***Planning Department  
Transportation Development Services***

**Re: Santa Fe Tow Lot #13  
8101 Jacs Ln., NE  
Traffic Circulation Layout**  
Engineer's/Architect's Stamp dated 11-17-15 (D16-D002A5)

SANTA FE TOW, ARMANDO BELTRAN — TRAFFIC CIRCULATION LAYOUT (TCL)

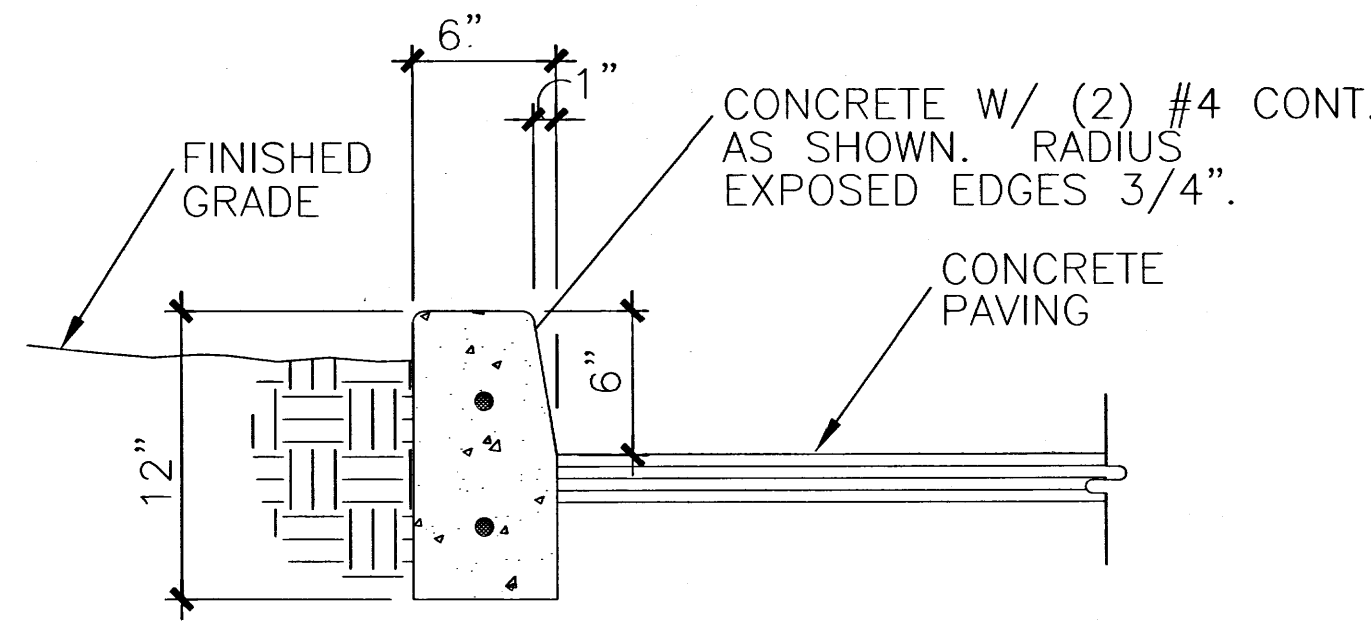
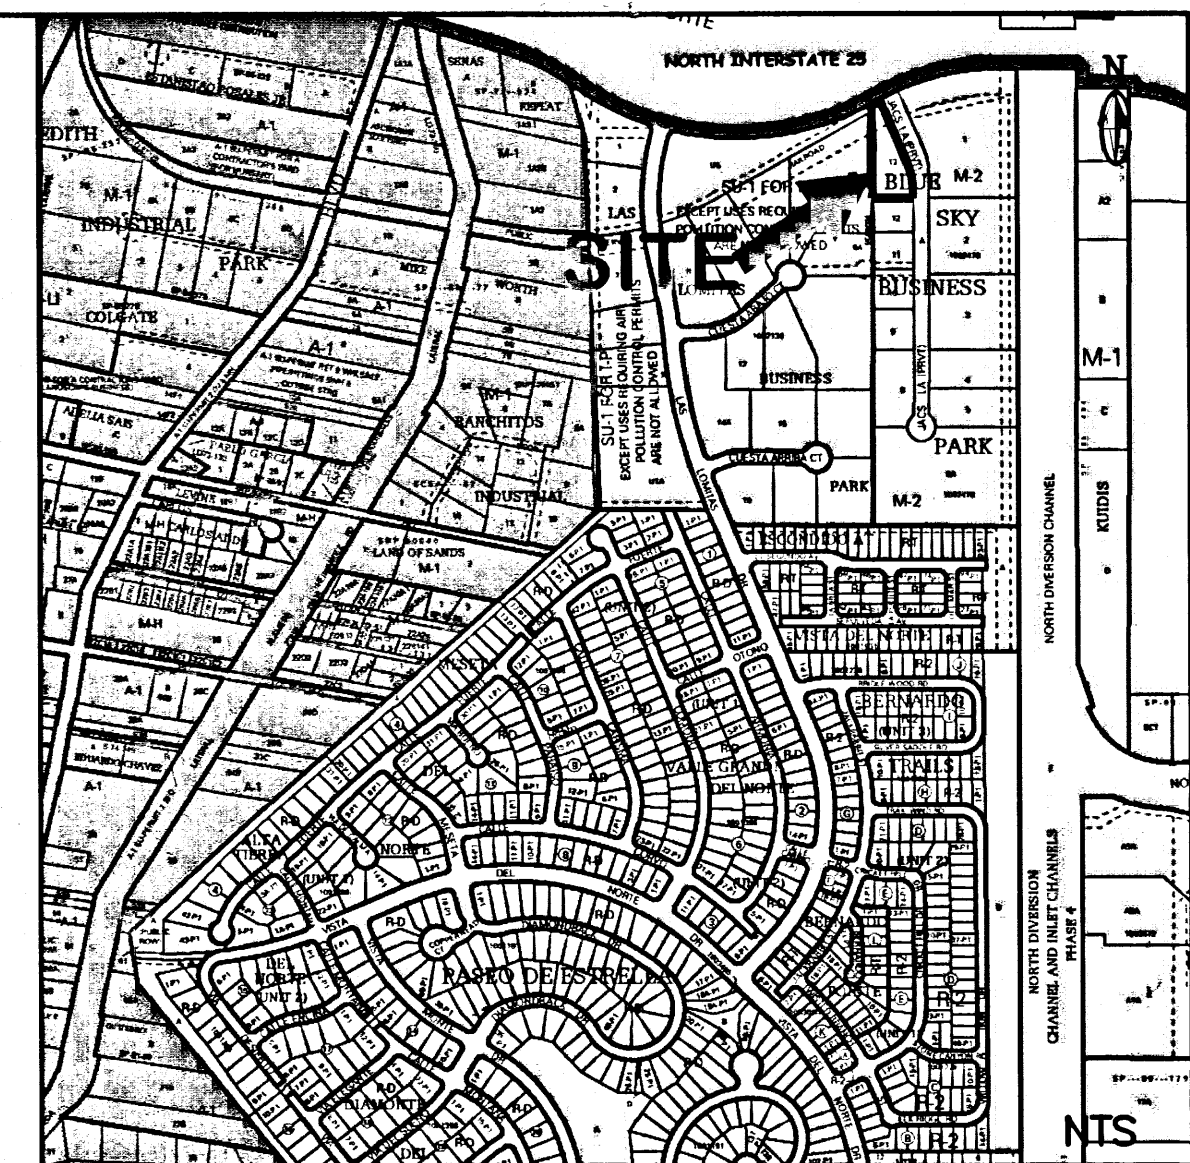
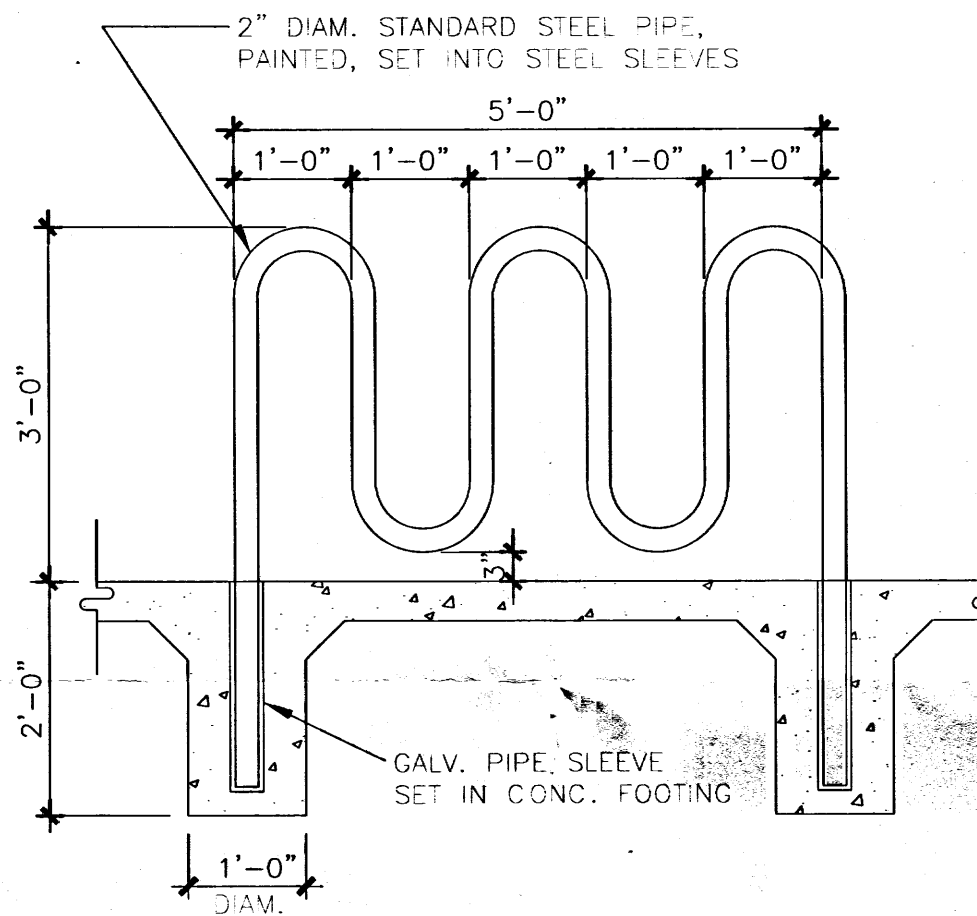
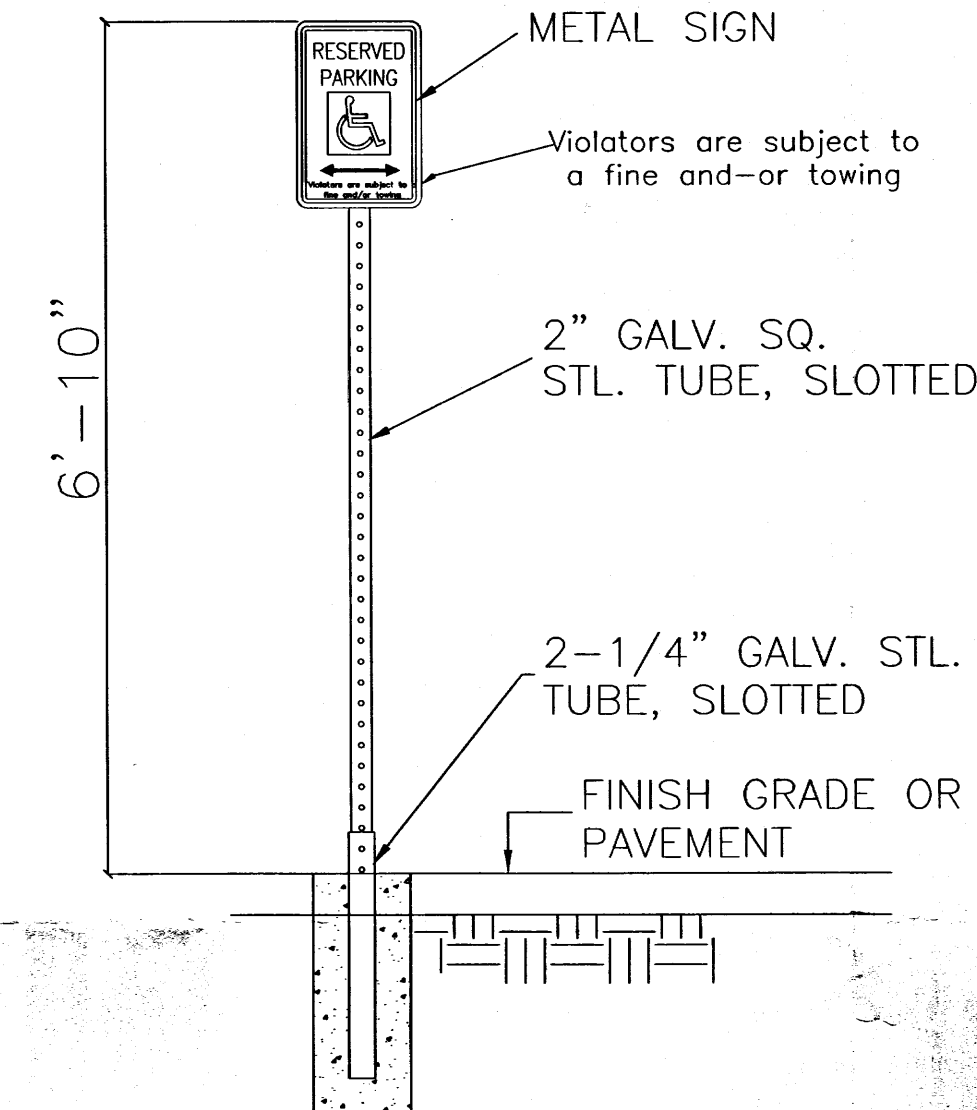
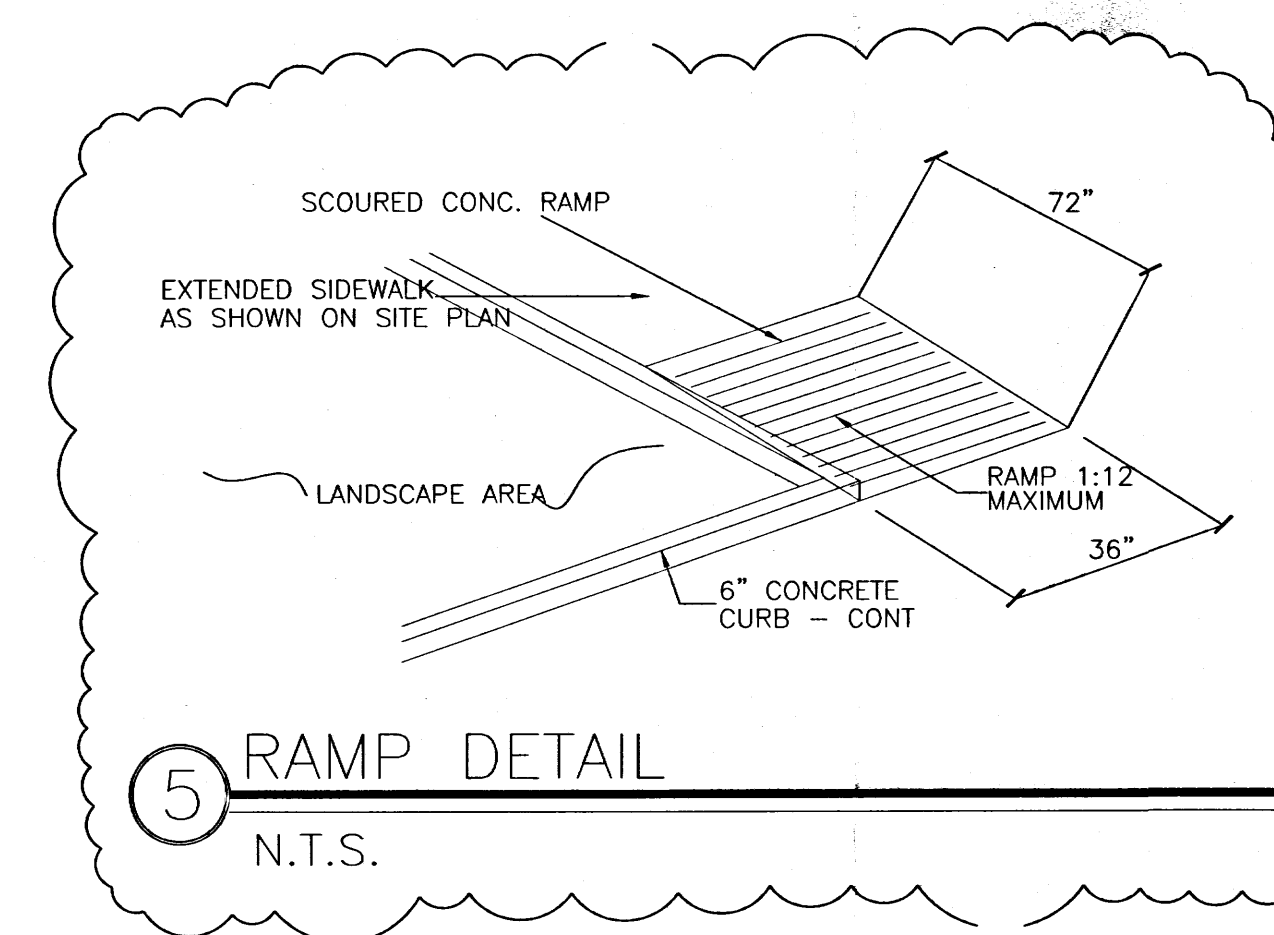
5. Per the DPM, a 6 ft. wide ADA accessible pedestrian pathway is required from the public sidewalk to the building entrances. Please clearly show this pathway and provide details.

6. Per the DPM, a 6 ft. wide ADA accessible pedestrian pathway is required from the HC parking stall access aisles to the building entrances. Please clearly show this pathway.

7. Provide a min 6" or max 8" high concrete barrier curb or other acceptable barrier between landscaping and parking areas and/or drive aisles.
8. Design delivery vehicle route needs to be shown.
